From: Simon Davis
Sent: 01 May 2019 17:04
To: [REDACTED]
Subject: RE: AL/27/19/DOC GTR DENMANS LANE FONTWELL

In your email to me of 22/03/19 you stated that you were still waiting for the final drainage details. Until you can provide these to me, I don't see that our engineers can agree the condition approval.

FOUNDATION NOTES :-

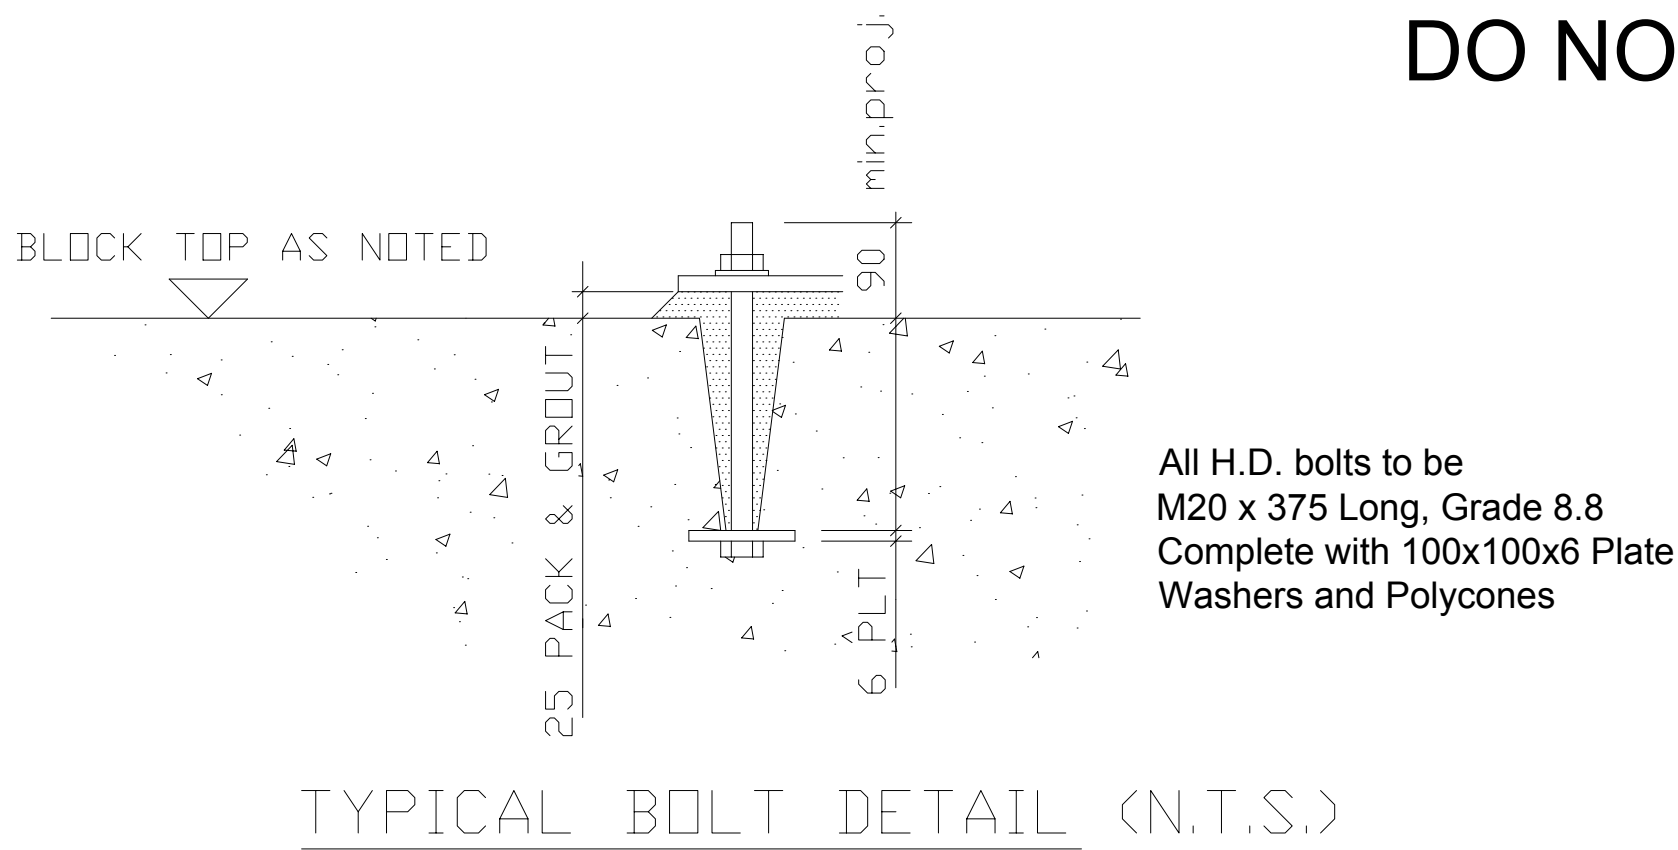
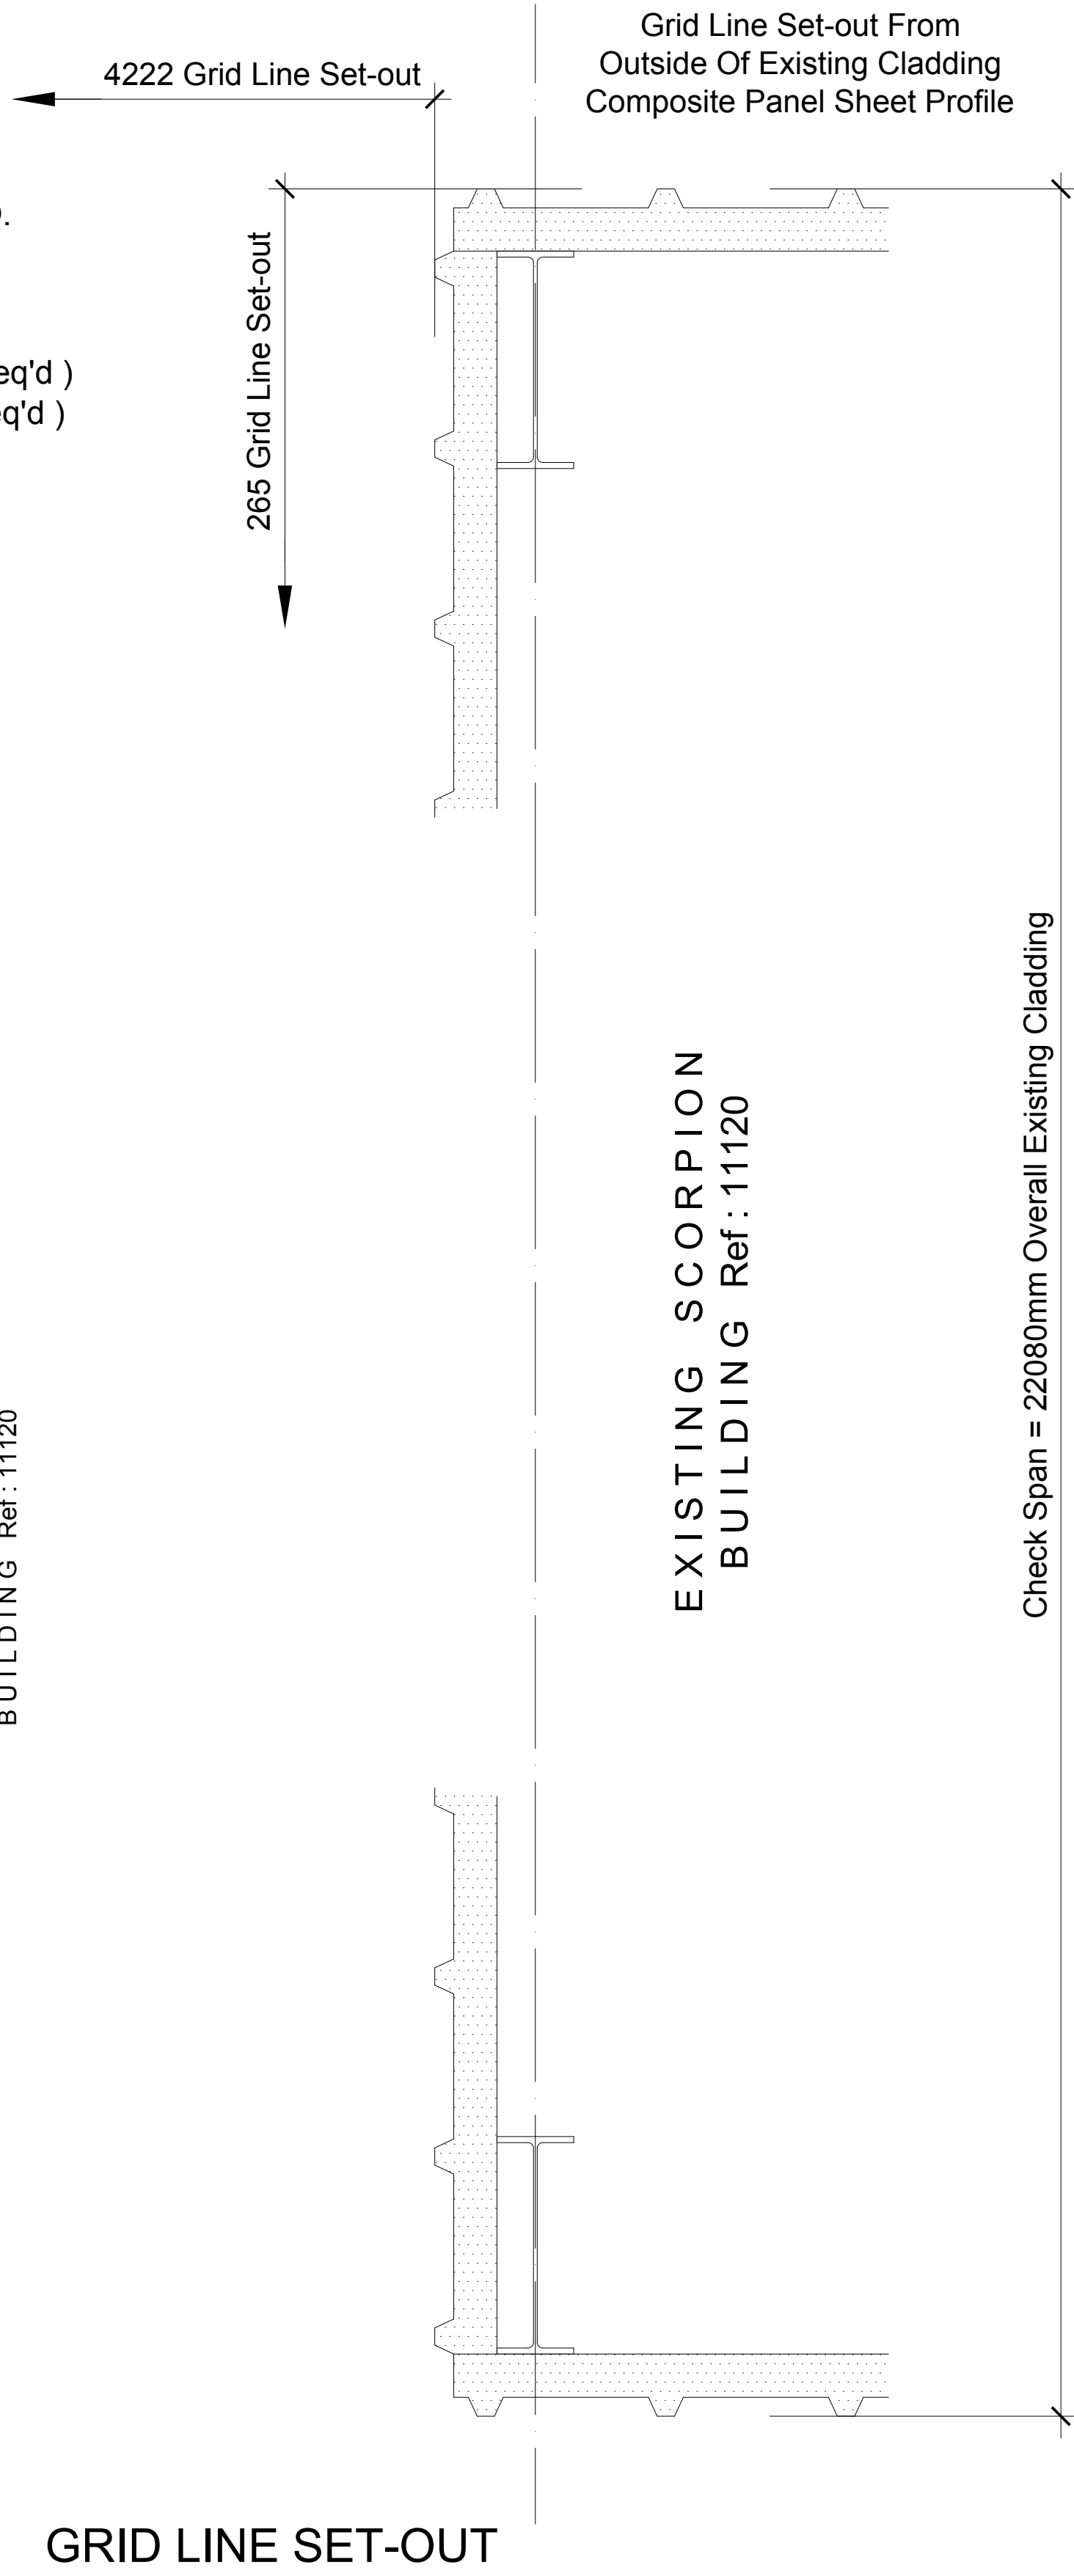
Regarding condition 08, this only requires discharge if you are using piling or other foundation designs using penetrative methods. You state that piling or trenching will not be used but you are proposing a foundation depth of 1.75m. Therefore, do I assume that you are using a penetrative method? We have consulted the EA and I have not yet heard from them so I will chase today.
